SHOALHAVEN CITY COUNCIL
ENVIRONMENTAL ASSESSMENT SUBMISSION TO THE NSW DEPARTMENT
OF PLANNING PART 3A, ENVIRONMENTAL PLANNING & ASSESSMENT ACT, 1979

MAJOR PROJECT APPLICATION MP 06_0205

Vincentia District Centre
Modification No 5

PROPOSAL: Proposed MP06_0205 VDC Stage 1 - Modification No 5 being a modification to the VDC Stage 1 approvals issued in Modifications 2, 3, and 4.
Delivery of the VDC in two stages with an amended floor layout design and Statement of Commitments and proposals for a fuel and fast food outlet in Stage 1.

SWEPT PATHS

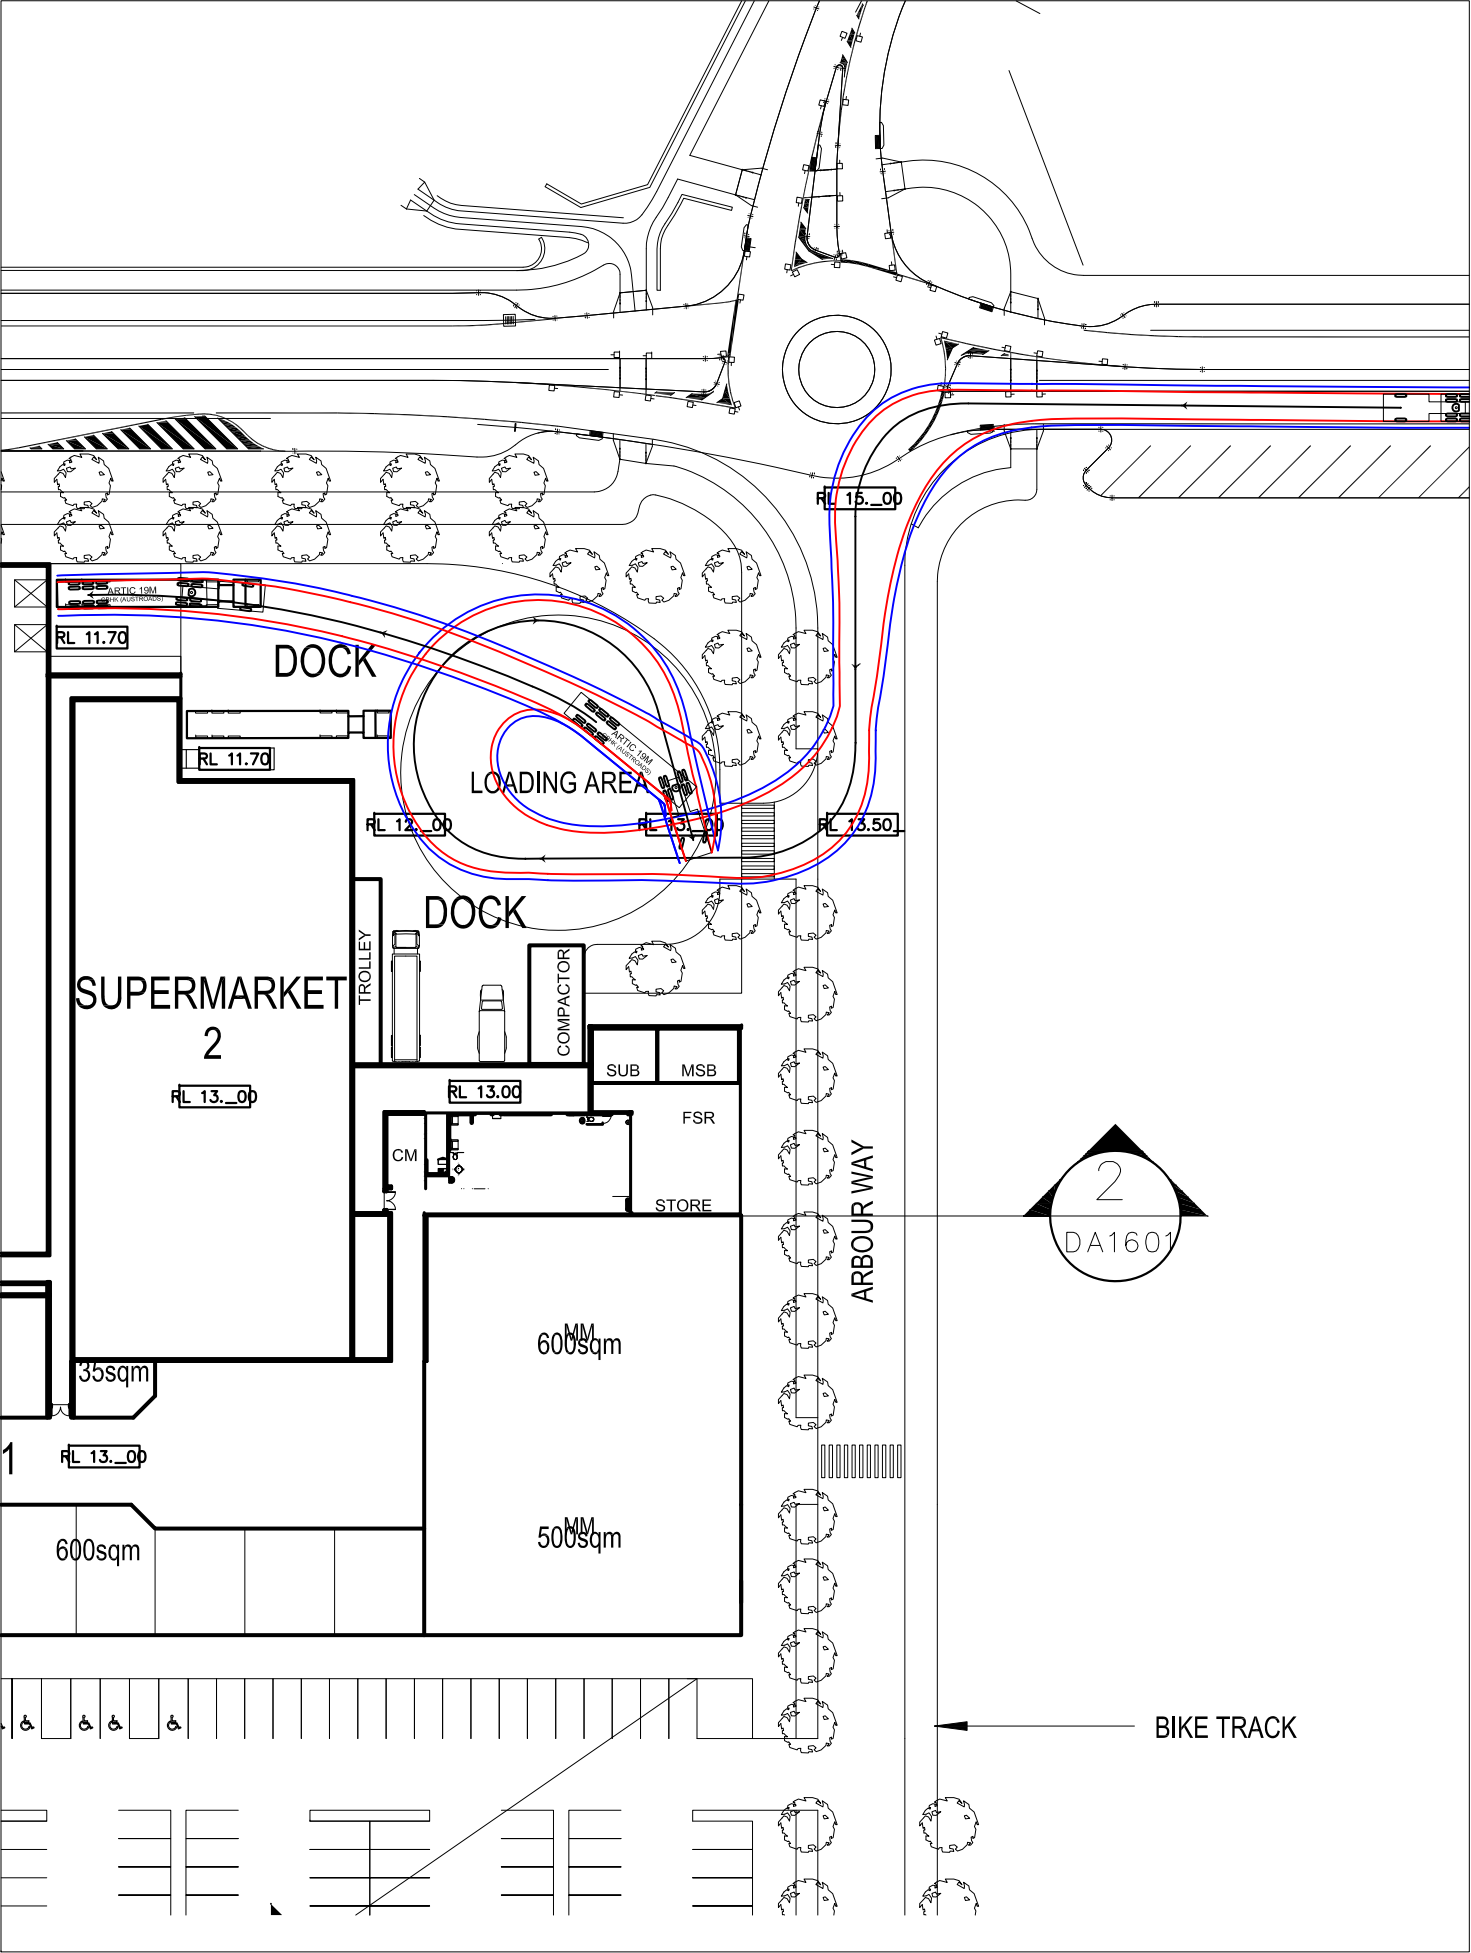
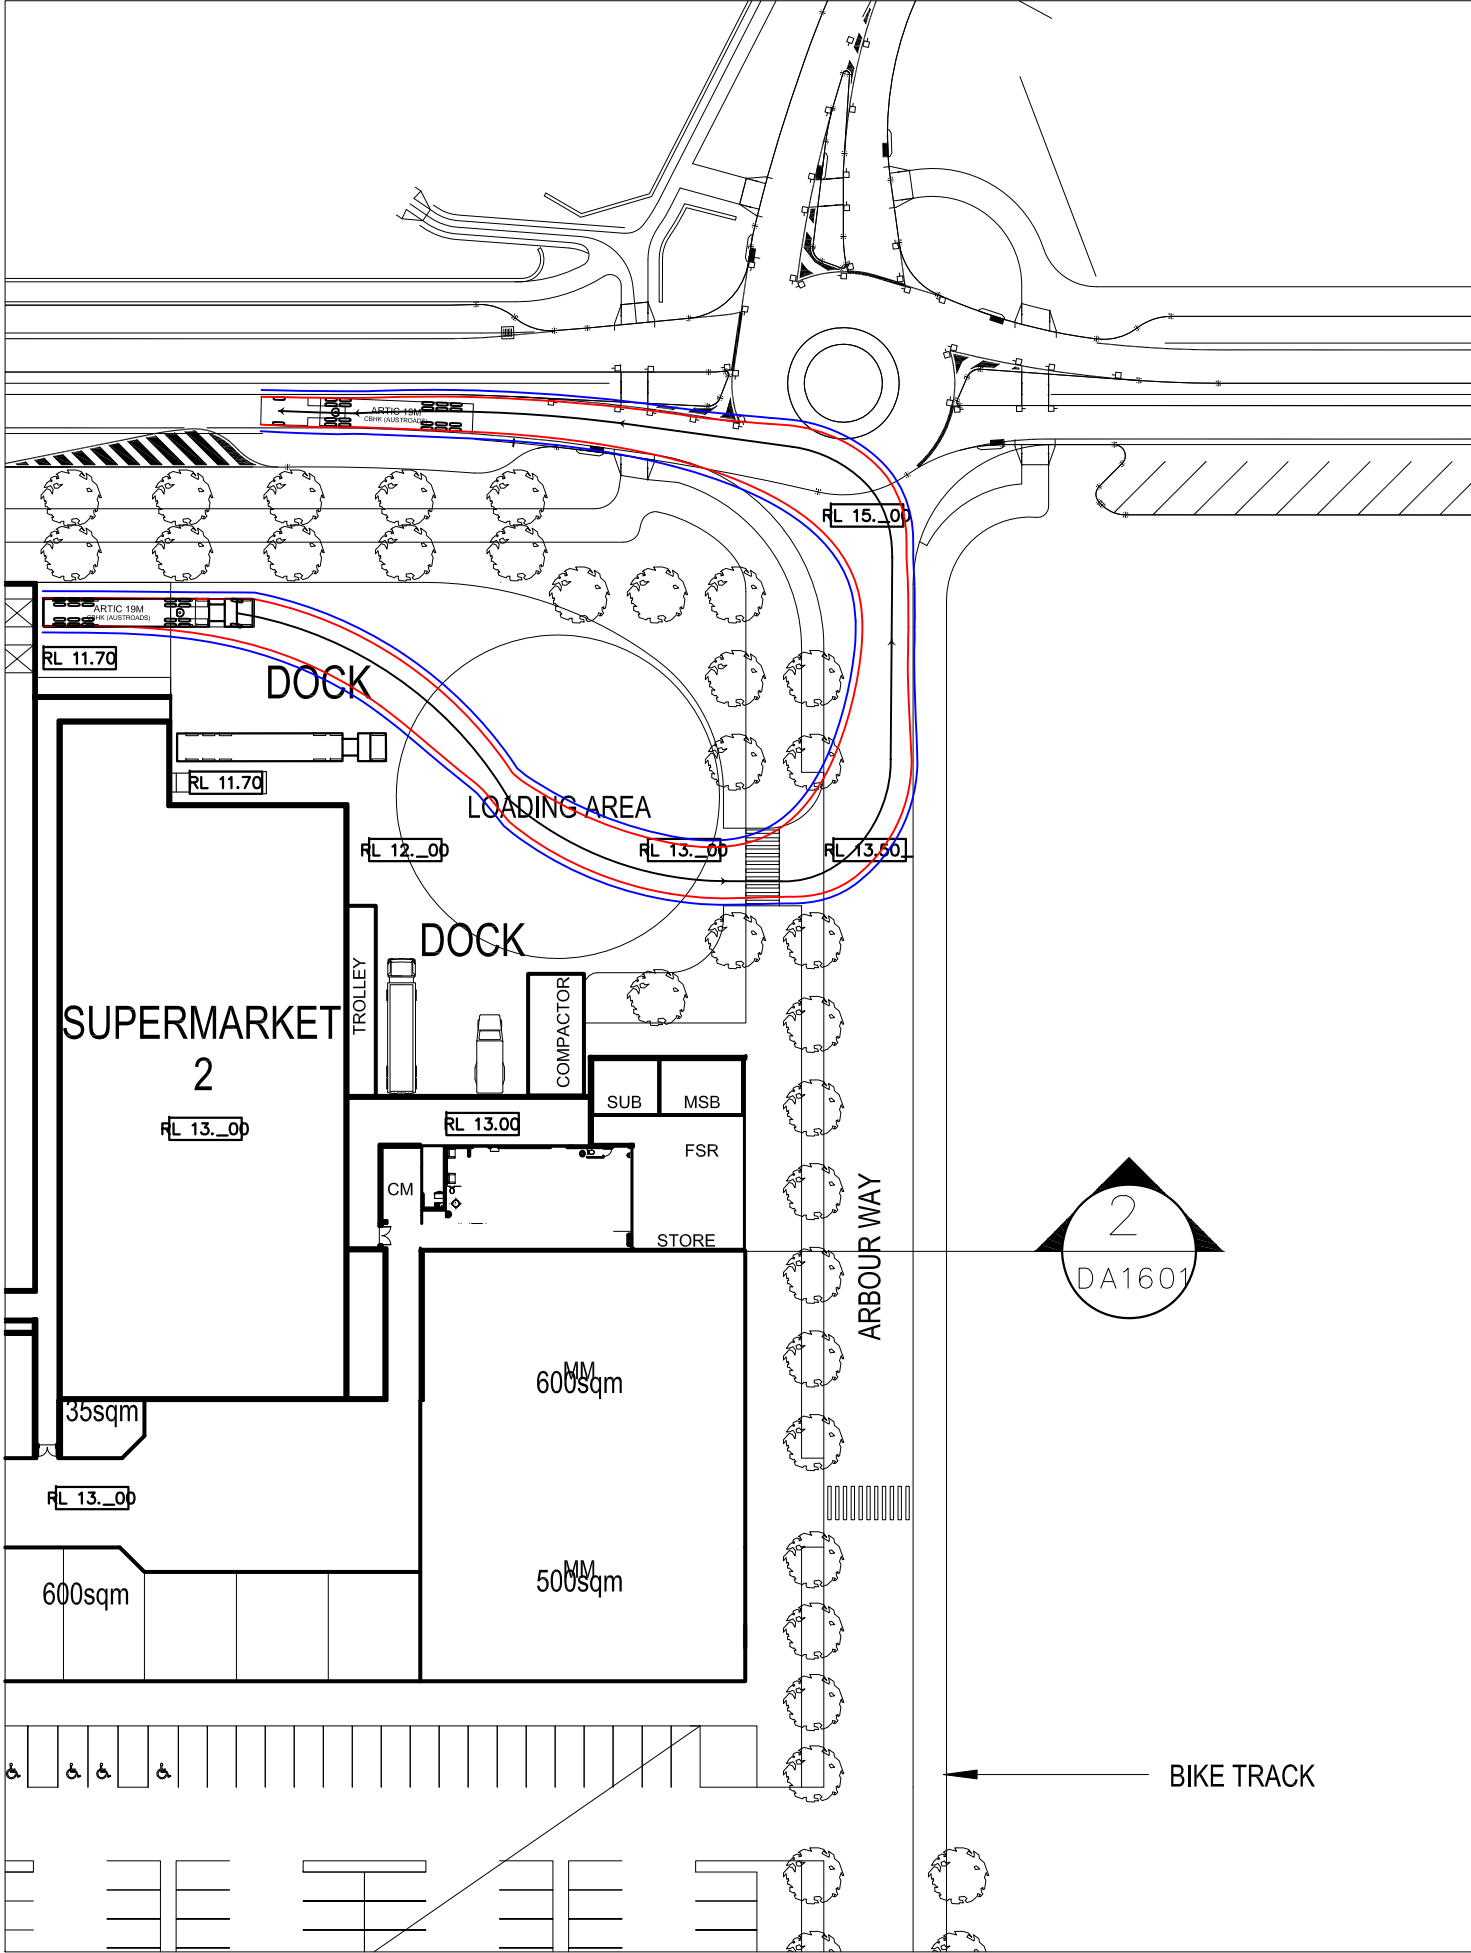
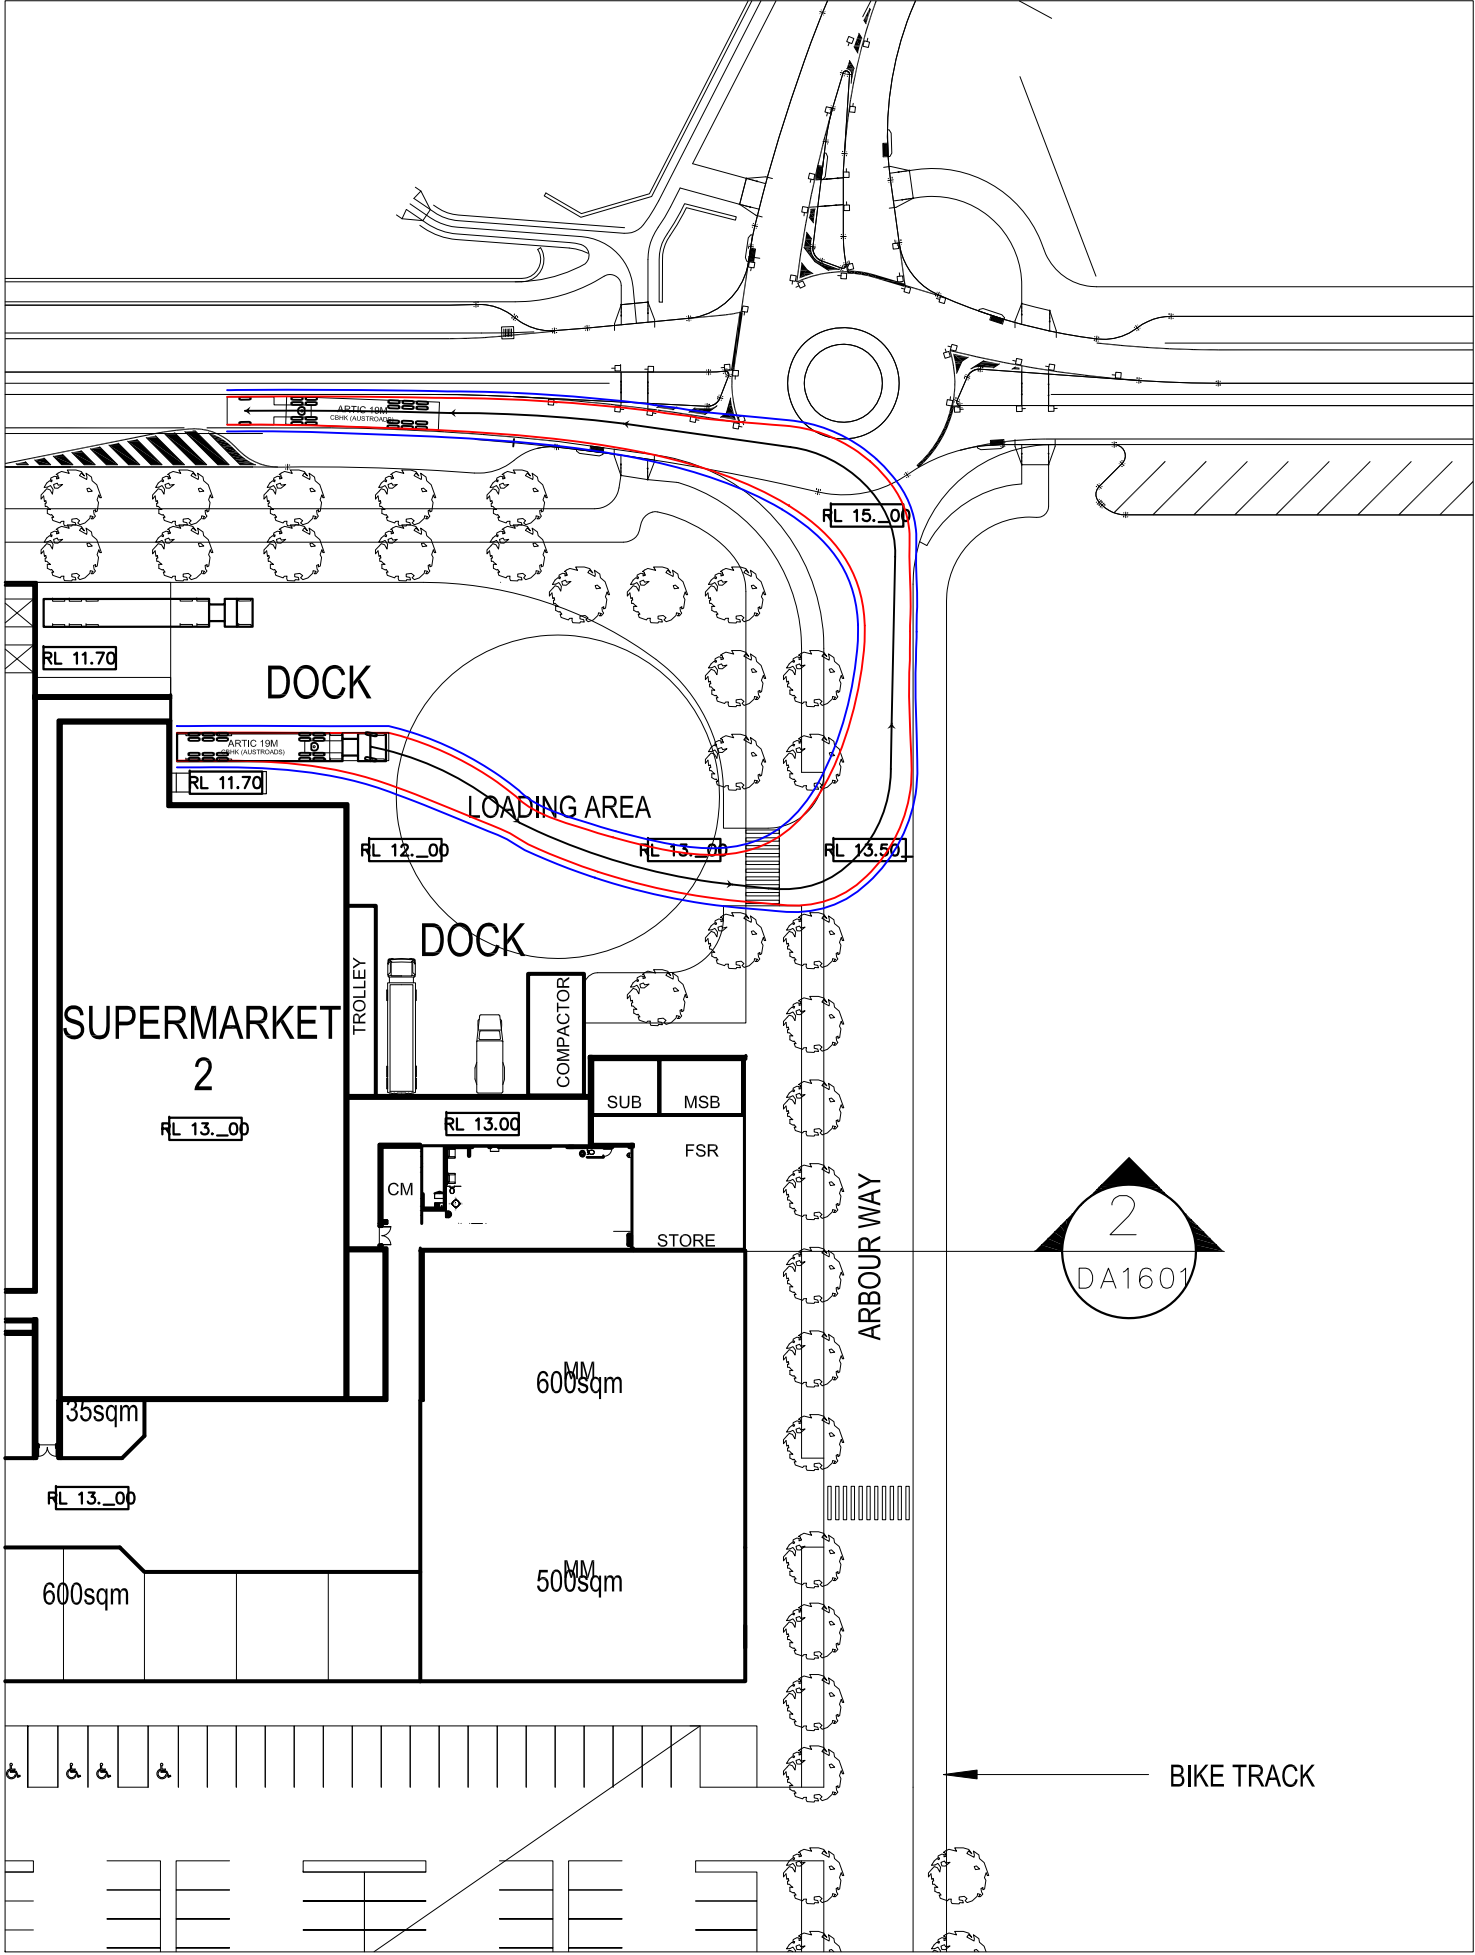
The Colston Budd Hunt & Kafes Pty Ltd (CBHK) Stage 1 report includes vehicle swept paths for the Stage 1 loading dock. However, the CBHK Stage 2 report does not include swept paths for the two loading docks for the retail and bulky goods buildings and this will be required to validate the practical use of the loading docks.
